**KIRKLEES METROPOLITAN COUNCIL
INVESTMENT & REGENERATION SERVICE**

Reference No:	2024/62/93055/E
Site Address:	Land Adj, 2, Hopton Hall Lane, Upper Hopton, Mirfield, WF14 8EP
Description:	Erection of detached dwelling and associated external works
Recommending Officer:	Edward Cheseldine

DECISION – Refused

Officer Report

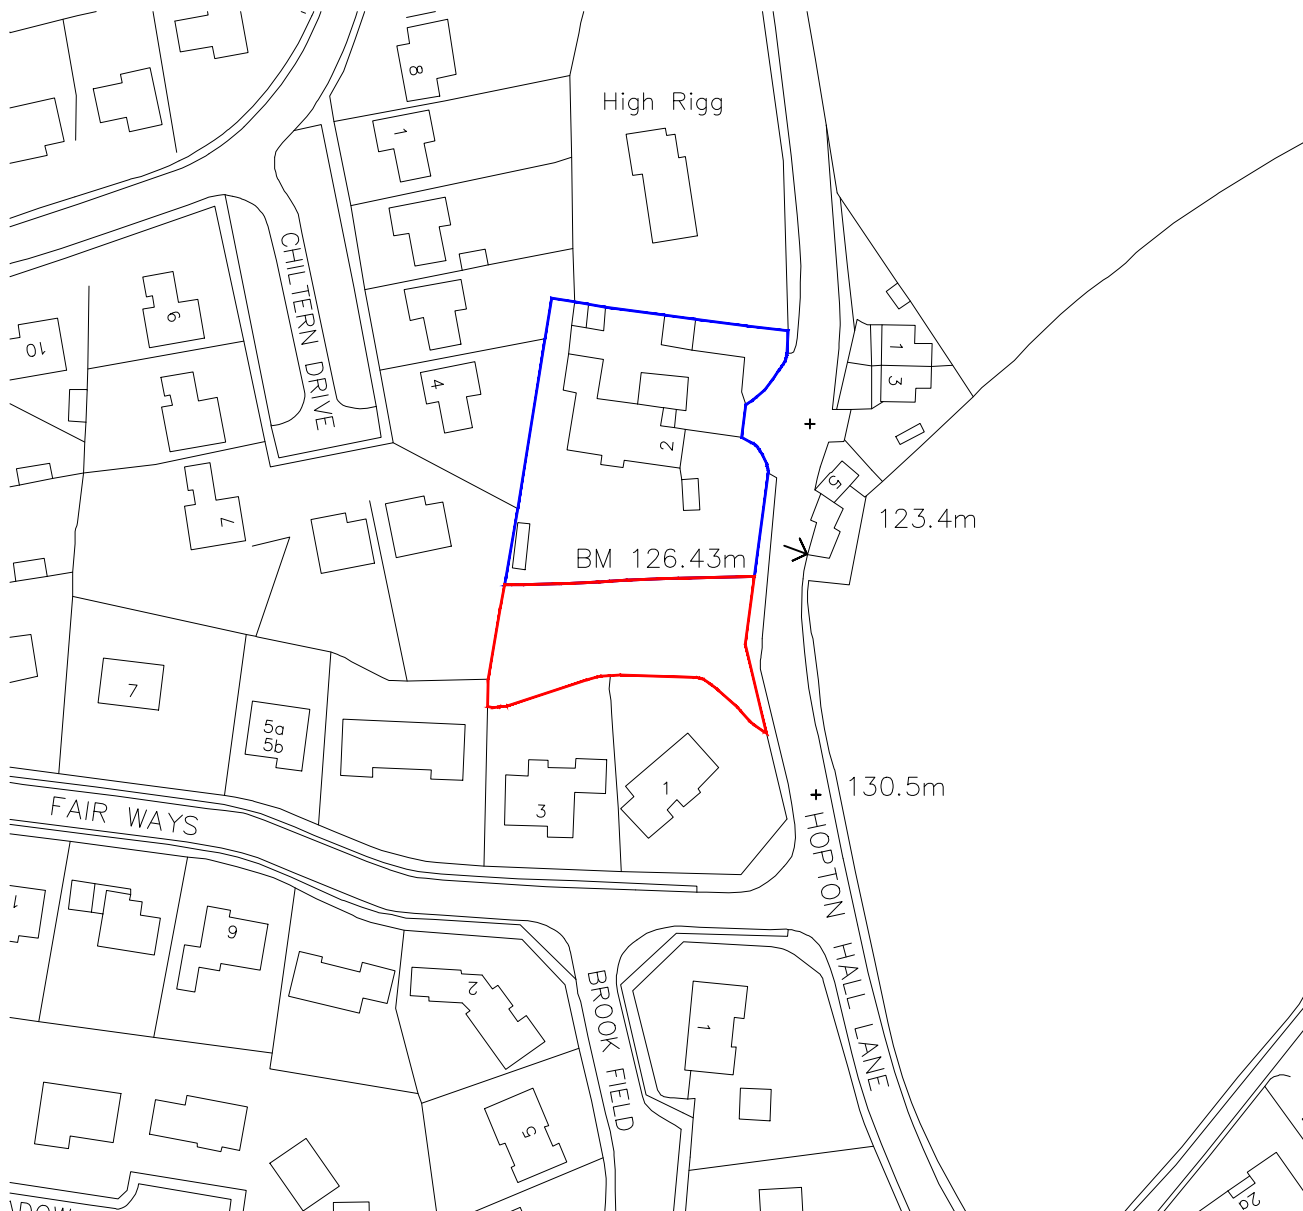
The Root Protection Area (RPA) of T1 tree overlaps with the proposed driveway and access route onto the site. These proposals cause concern as the total overlap of the driveway and access route covers a significant portion of the total RPA. According to BS5837: 2012 new permanent hard surfacing should not exceed 20% of any existing unsurfaced ground within the RPA.

To reduce the tree impacts to protected tree T1, a no-dig methodology is proposed for the construction of the driveway. However, root-pruning is currently proposed for the access route onto the site. The proposed area of root pruning would represent a loss of 11% of the total RPA. This level of root pruning could jeopardise the long-term health of protected tree T1.

To avoid root pruning within the RPA of T1, it is suggested that the area of no-dig construction for the proposed driveway is extended to include the area of the site access. The use of a cellular confinement system, or suspended driveway would prevent root damage and soil compaction, helping to avoid unnecessary damage to the long-term health of the protected tree.

KC Trees therefore objected to the proposal until an alternative solution is submitted to minimise the conflict between the RPA of the protected tree T1 and the proposed site access route.

EAST ELEVATION  
1:100

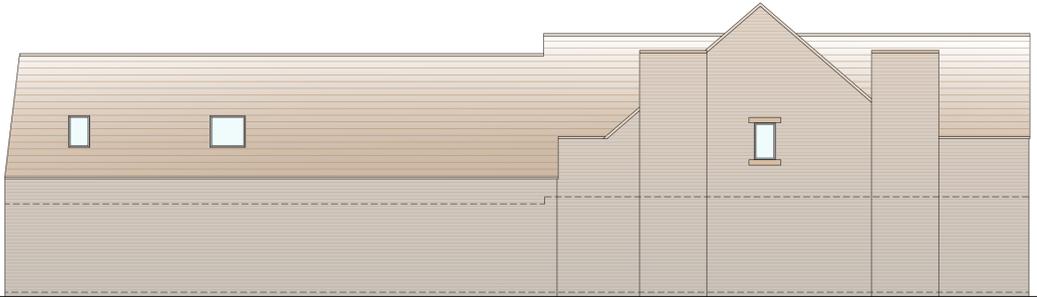
The property features a cross-hipped roof form. As per the assessment relating to Principle 4, the vertical massing of the ridgeline is not proportionate to the site due to its length being ~28.60m. The massing runs down the side of the plot at a height of ~6.80m. The design of which does not respect the existing spatial pattern or the topography of the site.

There is significant vertical and horizontal massing on the southern border of the application site due to the gable-end of the front section of the building. 1 Fairways is a 2 storey dwelling. It is acknowledged that 1 Fairways is set a 45 degree angle to the application dwelling, however, the gable-end is ~8.70m in height at a section that is observable from the rear facing windows. Sight section plans indicate the sitting of the gable-end will result in a partial loss of outlook which is against Principle 6 of the House Builders Design Guide Supplementary Planning Document.

The gable-end is ~1.80m from the boundary treatment, at the point of the centre of the garden space. Due to the height and massing of the gable-end, there would be a sense of enclosure within the garden and from habitable rooms to the rear of the property.

GROUND FLOOR PLAN  
1:100

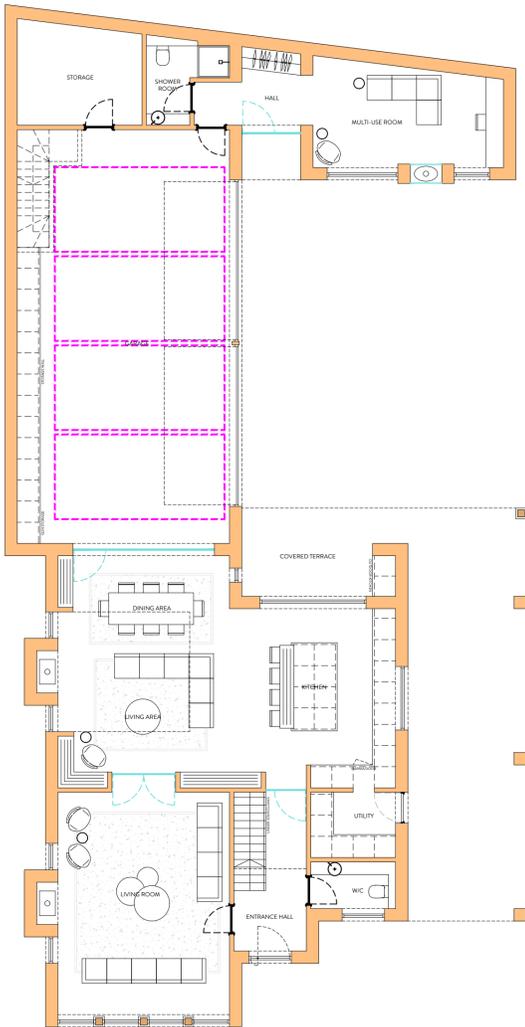
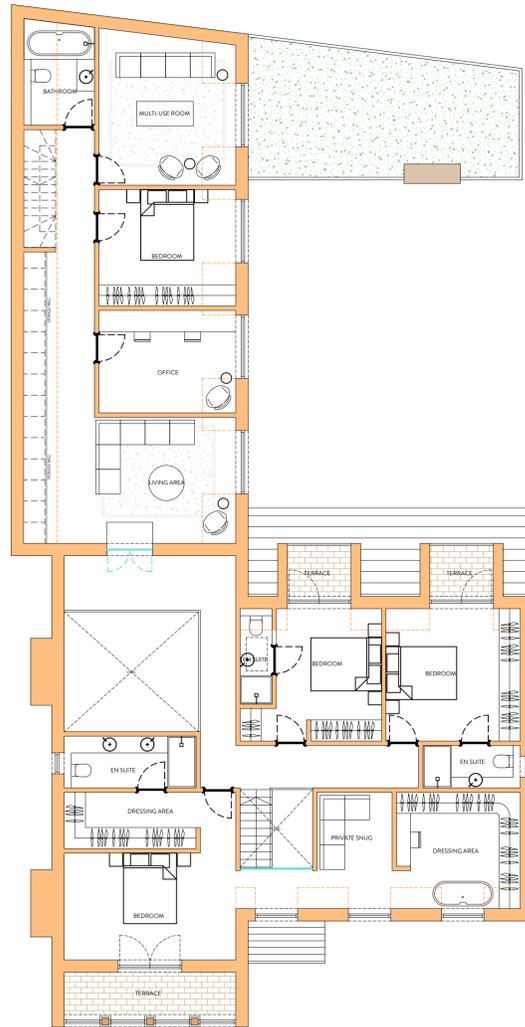
2 Hopton Hall Lane sits ~18.80m to the north of the application dwelling. In terms of privacy, there is a window within the gable-end which the floorplans indicate will be a bathroom. If the application was approved, it would be conditioned this window is obscurely glazed to meet the requirements of LP24b. In addition, there are several side facing dormer windows facing the direction of this dwelling which are 9.35m from the boundary. In terms of an impact to the privacy, Principle 6 states there should be 10.50m between windows and boundaries of undeveloped land. The dwelling sits at a greater

1 Fairways is set away at a 45 degree angle to the application dwelling. In terms of privacy, there is a bathroom window on the gable-end with a close relationship. As before, if the application was minded for approval, it would be conditioned it is obscurely glazed. In addition, there are ground-floor windows, however the existing boundary treatment would obstruct the outlook of these windows.

5 Chiltern Drive is located to the north-west of the development site. The plot shares its boundary with the west of the development site. The nearest overlooking window lights a 'multi-use' room (living room) on the first-floor of the rear projection. There is an overlooking relation from the window into neighbouring outdoor amenity space. The window is positioned at a first-floor height, it will have unobstructed views into neighbouring, private outdoor amenity space. The outlook is positioned ~19.00m from the nearest window on the first-floor of No.5. Principle 6 states, there should be distance of separation of 21 metres between facing windows of habitable rooms at the backs of dwellings, which the plans do not accord with.
